FALCON LANDING
7344 MCLAUGHLIN ROAD
FALCON, COLORADO 80831

Option 1B
Elevations

Markup Summary

EXTERIOR ELEVATIONS
 DATE: 11.29.18
 DRAWN BY: CDGPS
 CHECKED BY: TDG
 PROJECT NO:
 SHEET:
9 OF 9

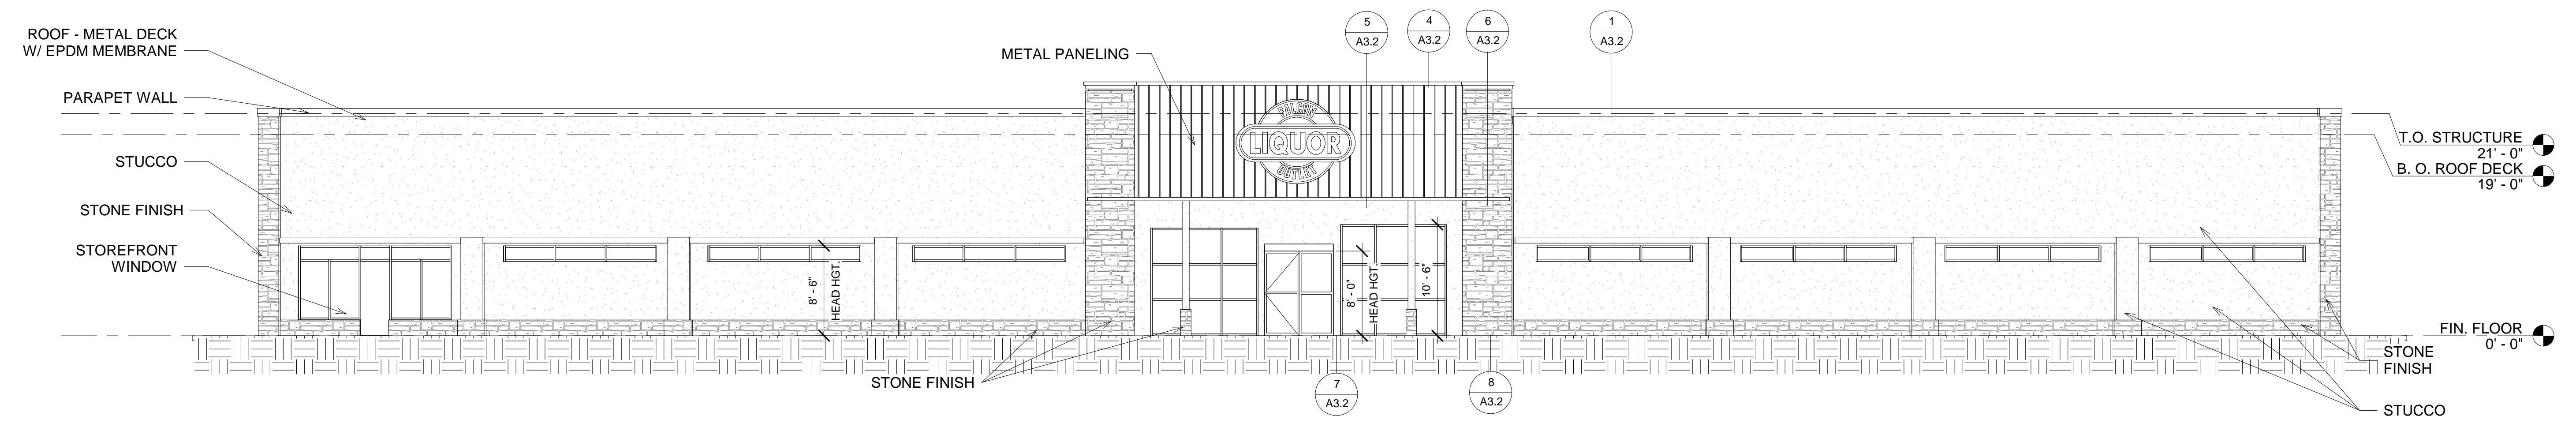
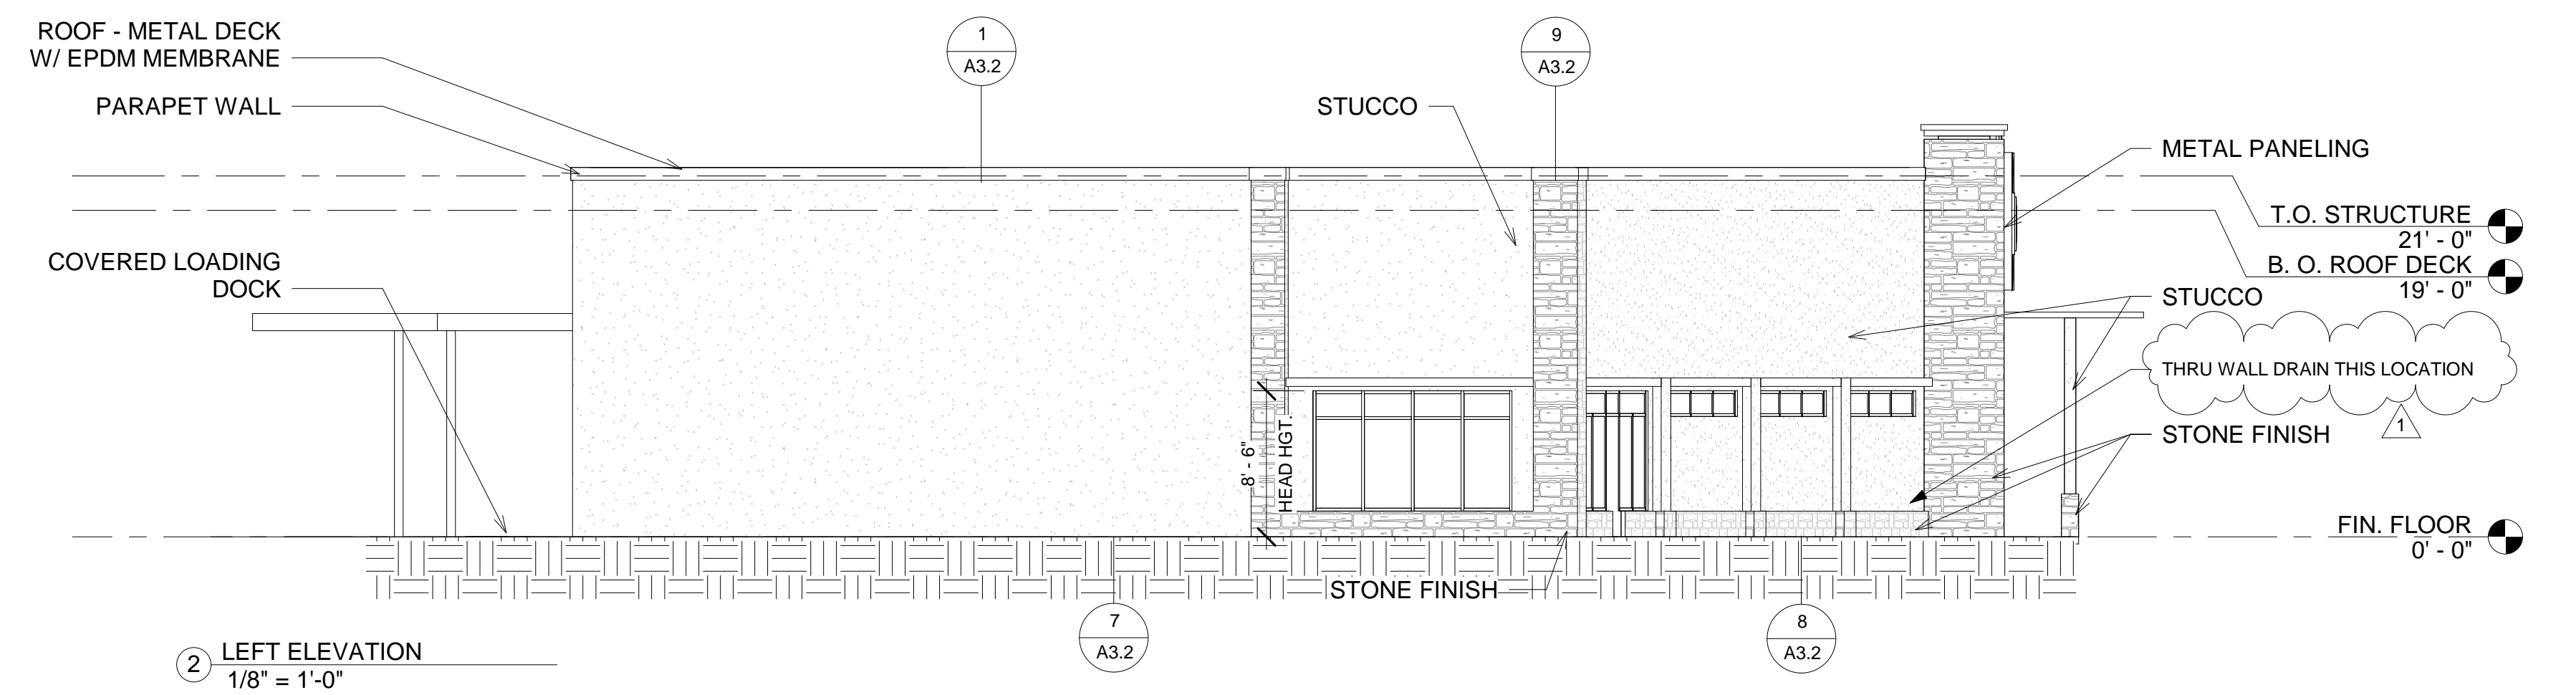
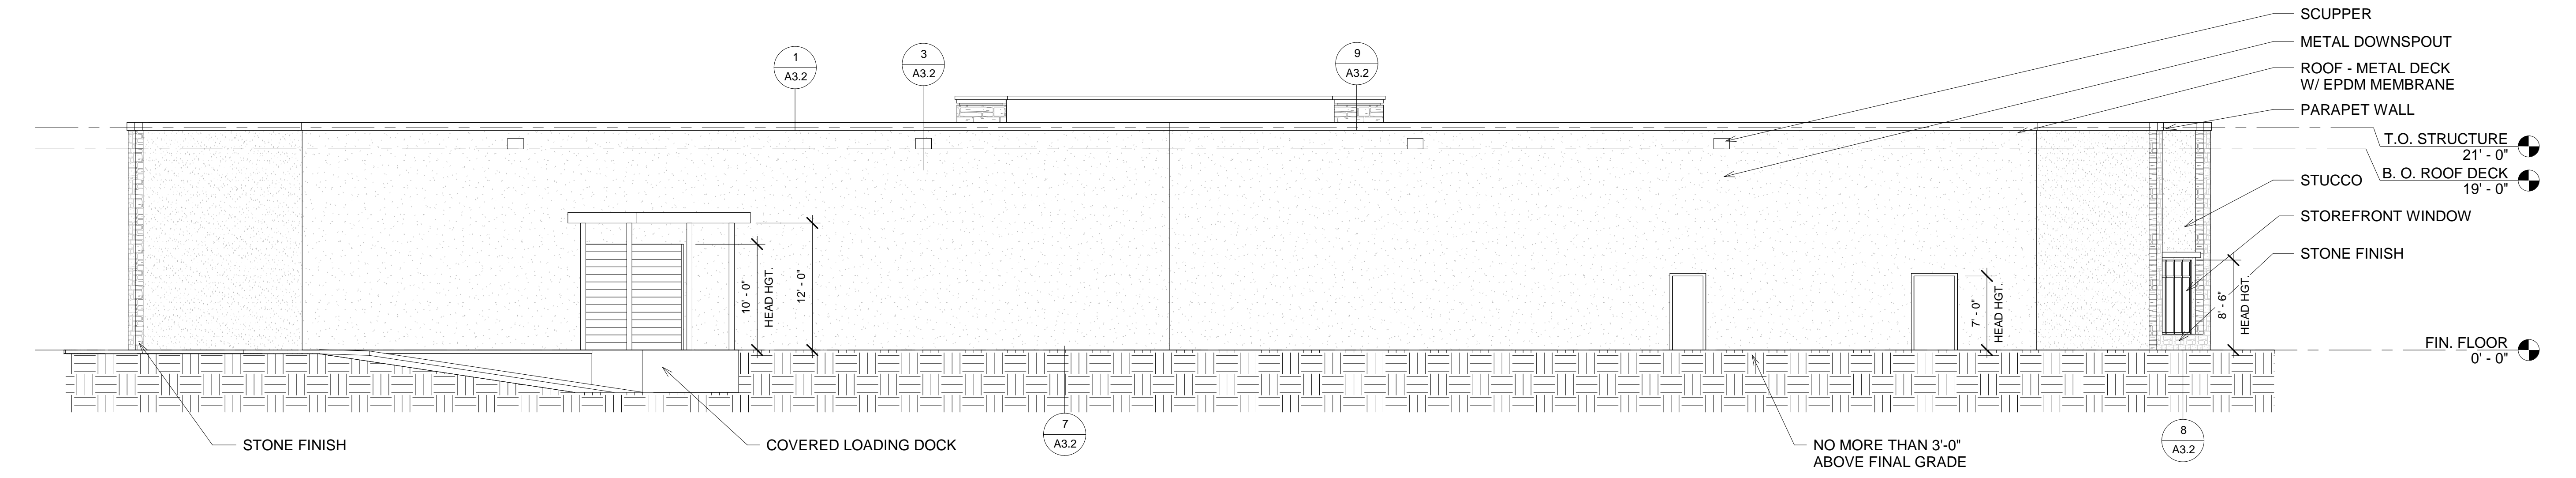
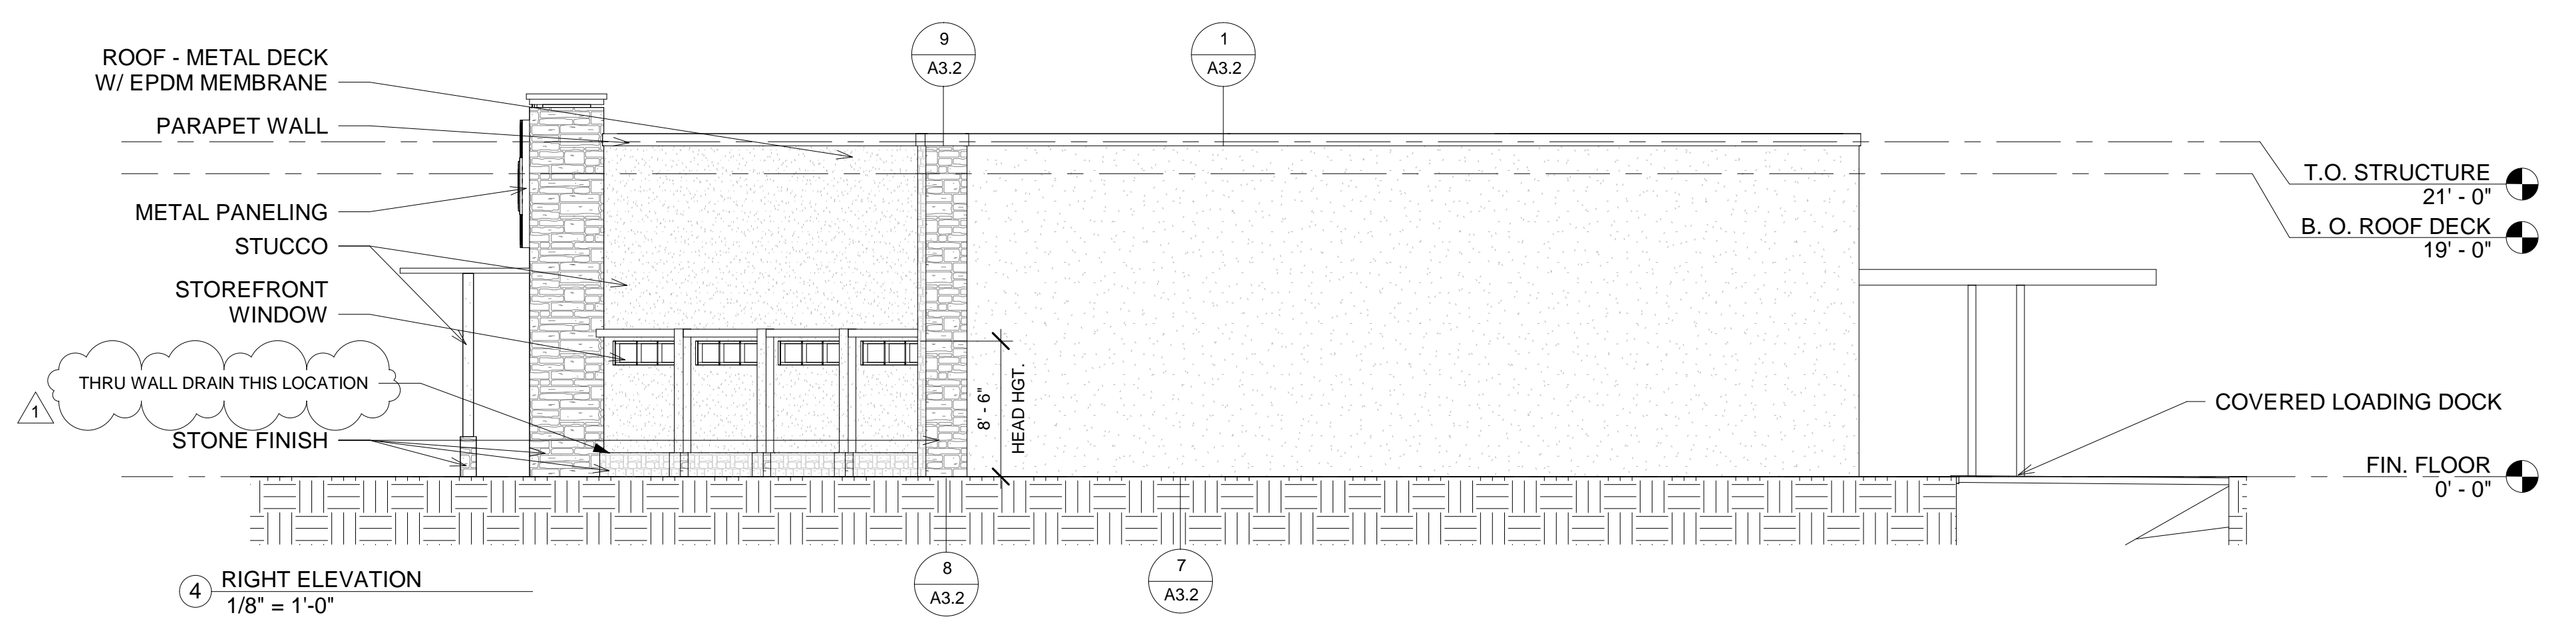
Please provide elevation details

what is this? Where is this on the site dev layout plan?

Does this building footprint match the SDP?
Please Dimension the elevations.
